**DESIGN CERTIFICATE BY THE CONSULTANT**

**PROJECT:** Eastern Creek Quarter - Stage 1, Eastern Creek

**LANDSCAPE ARCHITECTS:** Arcadia Landscape Architecture P/L

Arcadia Landscape Architecture hereby certifies that the landscape design prepared satisfies the Department of Planning Industry & Environment (DPIE) RFI comments listed below and to our best knowledge in accordance with SSD8588MOD3.

FLOOR PLAN - PARKING AREA SHADE SAILS 1 : 200

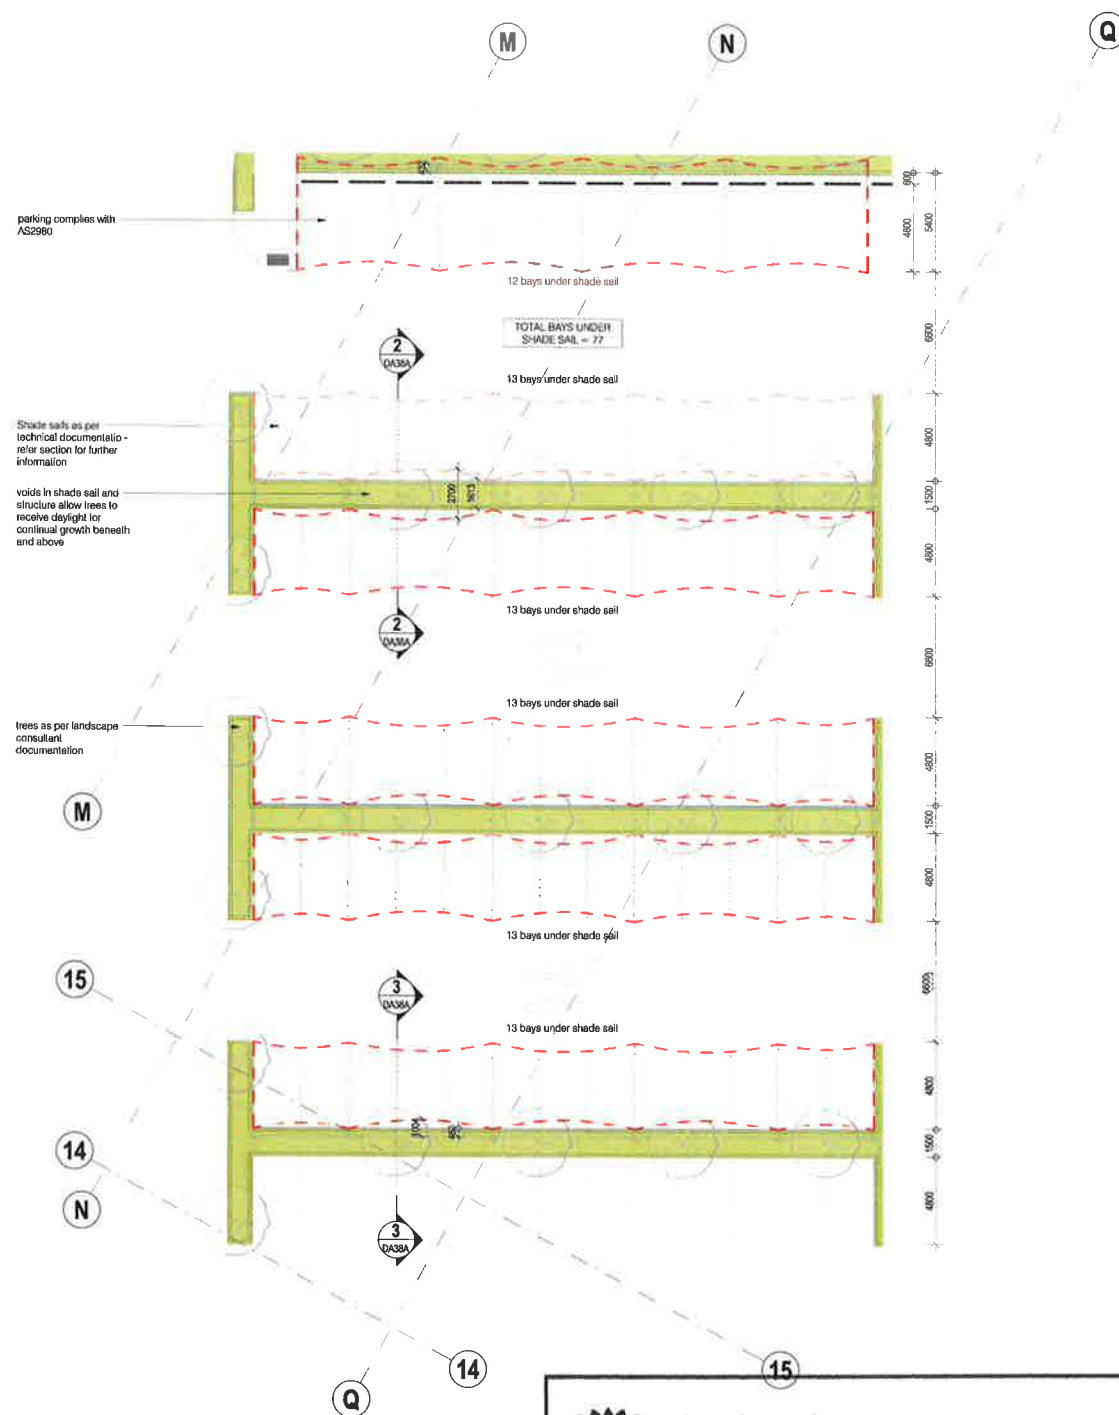
- Proposed *Corymbia maculata* trees will grow successfully between the car park shade sail void. The maintenance schedule will be updated to further accommodate maintenance strategy to ensure branches will be monitored as to not obstruct shade sail during establishment of mature tree.

- Landscape detail plan is correct in showing 7x *Corymbia maculata*
